From: Anita Gardner <Anita.Gardner@arun.gov.uk>
Sent: 11 December 2019 14:20
To: Planning.Responses <Planning.Responses@arun.gov.uk>
Subject: FW: M/80/19/PL - Former Poultry Farm, Yapton Road, Middleton

From: Mark Warwick <Mark.Warwick@arun.gov.uk>
Sent: 10 December 2019 14:54
To: Anita Gardner <Anita.Gardner@arun.gov.uk>
Cc: Sue Howell <Sue.Howell@arun.gov.uk>
Subject: RE: M/80/19/PL - Former Poultry Farm, Yapton Road, Middleton

I have particular interest in the **SOFTWARES PLAN, dwg. no. 402.6594.8_SWP_002_PO3, Rev 3, December 2019.**

402.06594.00008:14.TR04.RevB.dwg

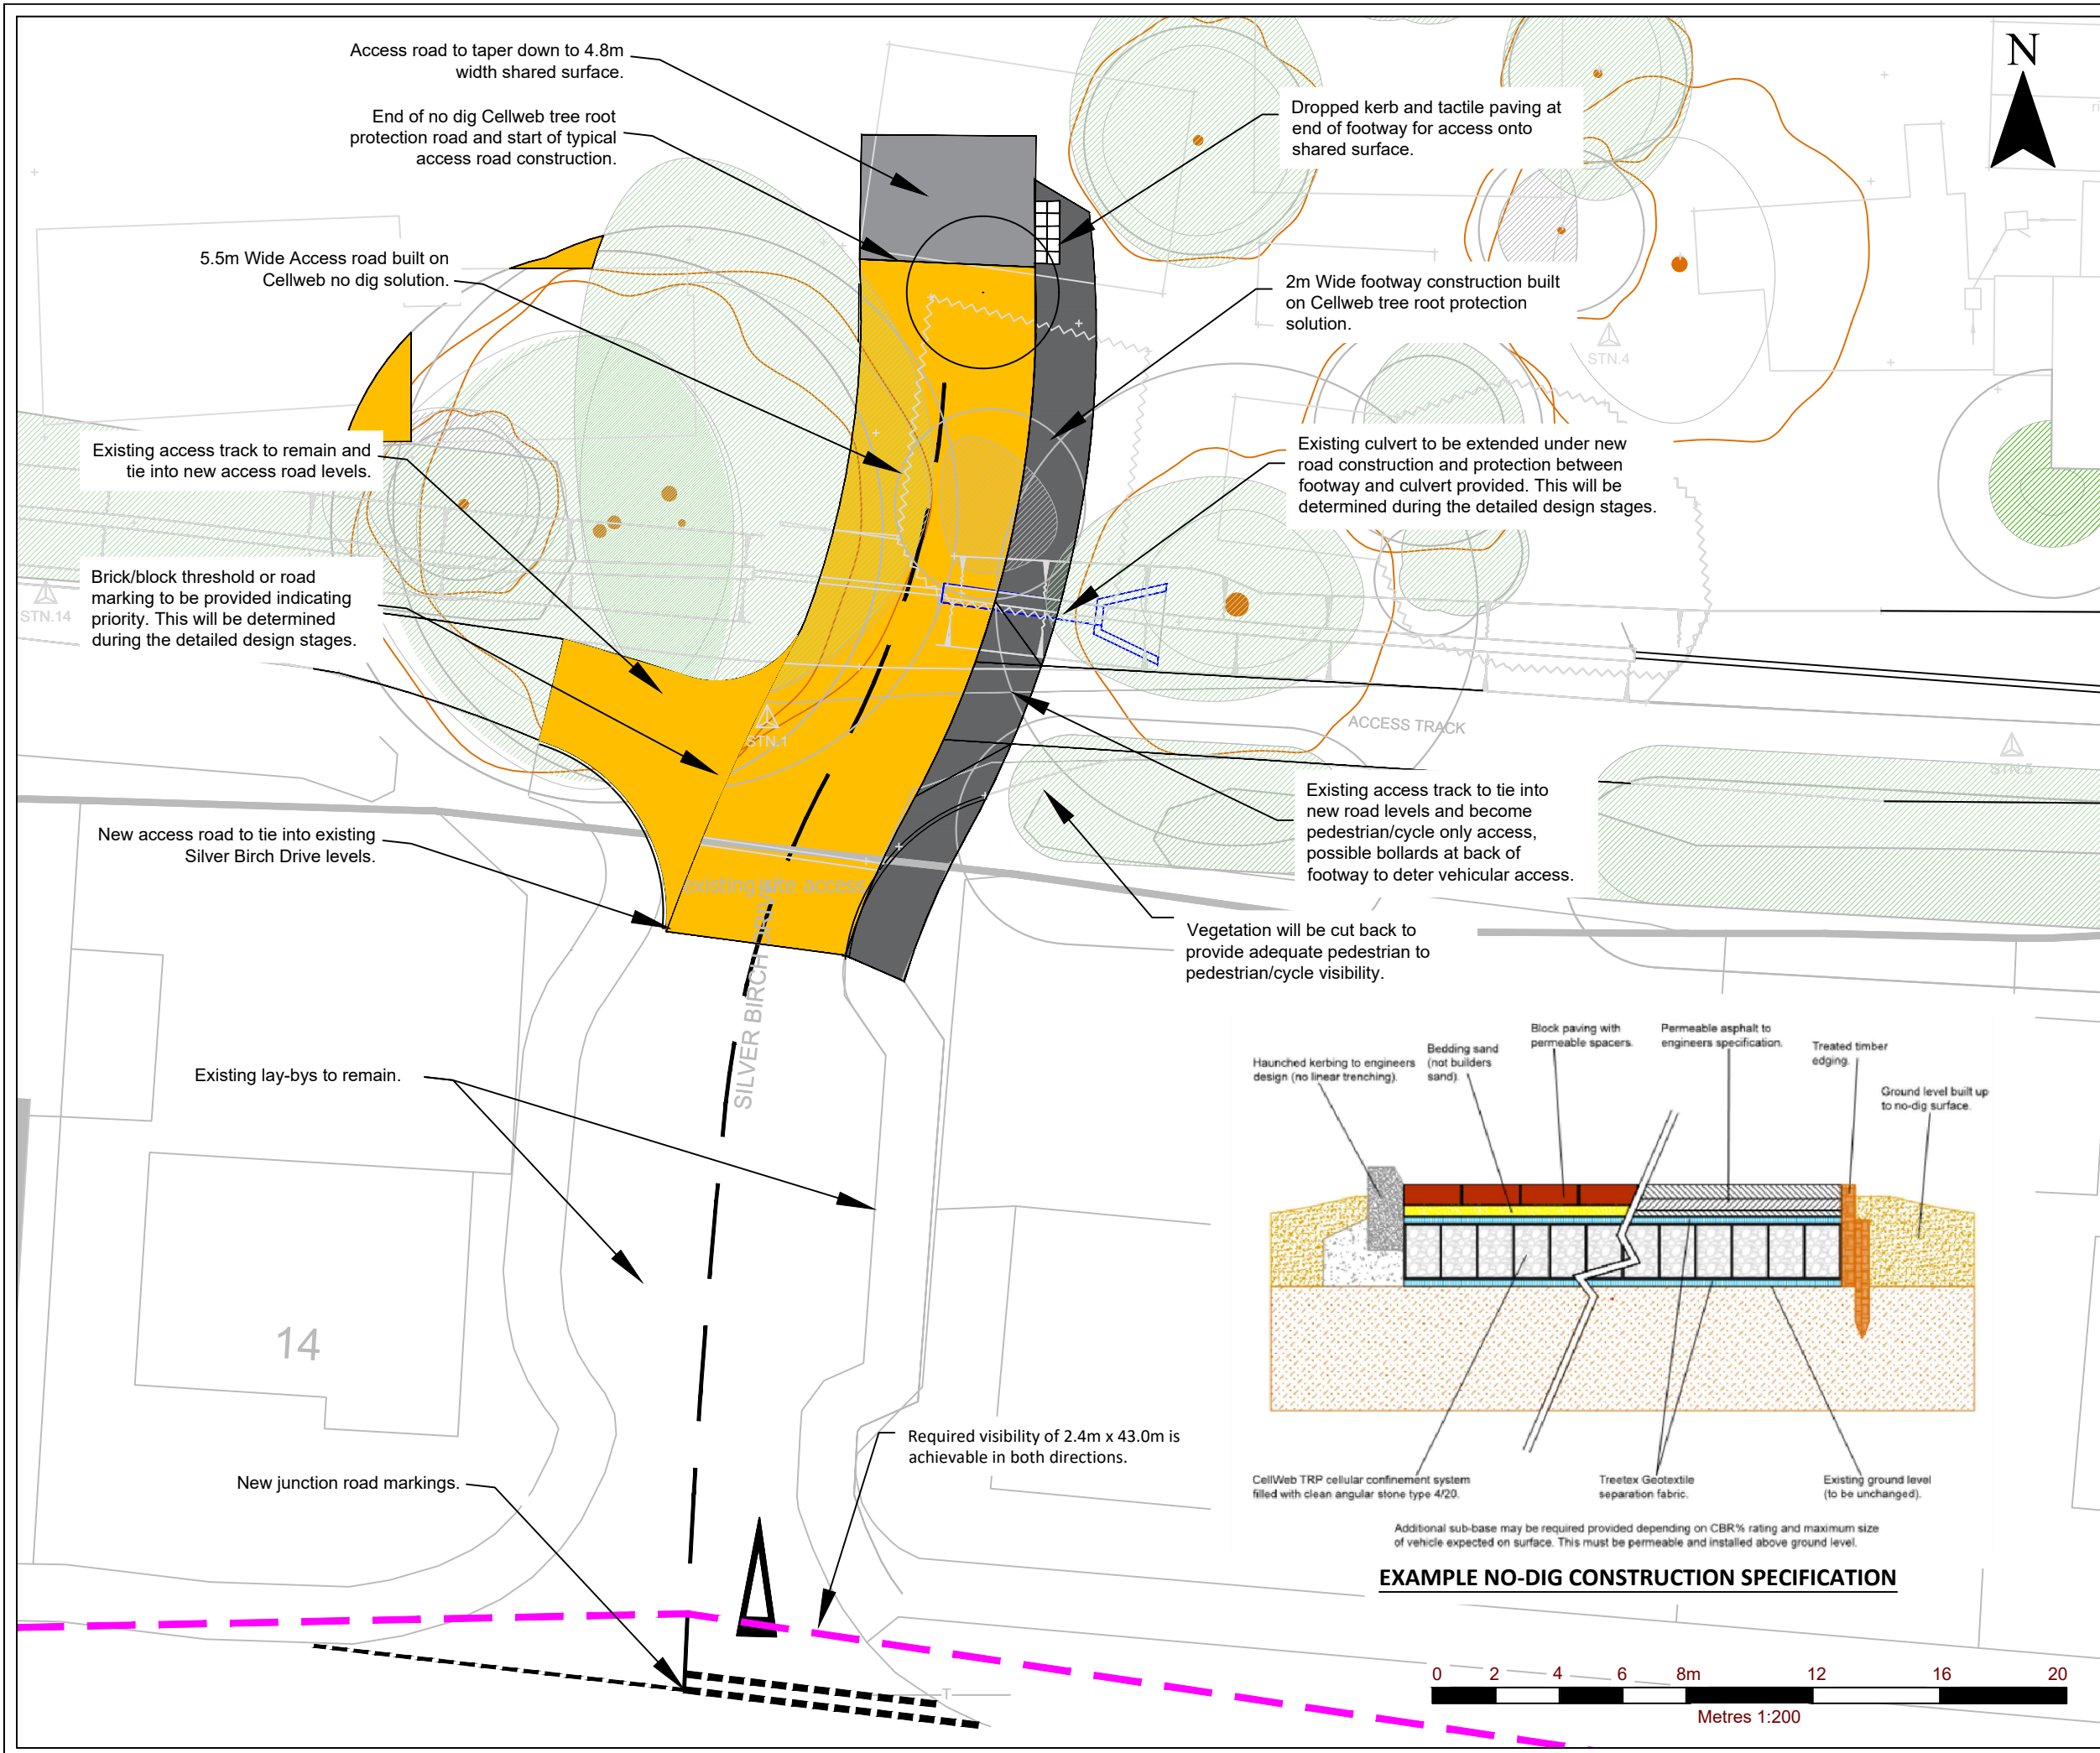
I note from **PJC Consultancy's letter of 27th November 2019** that the developer is keen to retain T4 and so the proposal is for a suite of tree protection measures about the site access to promote healthy, long-term retention of the same. I support this intention which is understandable and approve of their methodology whilst remaining open to the alternative of removing T4 (with caveat) if considered absolutely necessary on engineering grounds.

Notwithstanding the advice from the Council's tree officer that the removal of the ash tree might be possible, the applicant acknowledges the prominence of the tree at the site entrance and its importance to the wider community. The proposed engineered solution as outlined in drawing TR04 Rev B allows for its full protection and we note that the principle of this has now been accepted by the Council's tree officer.
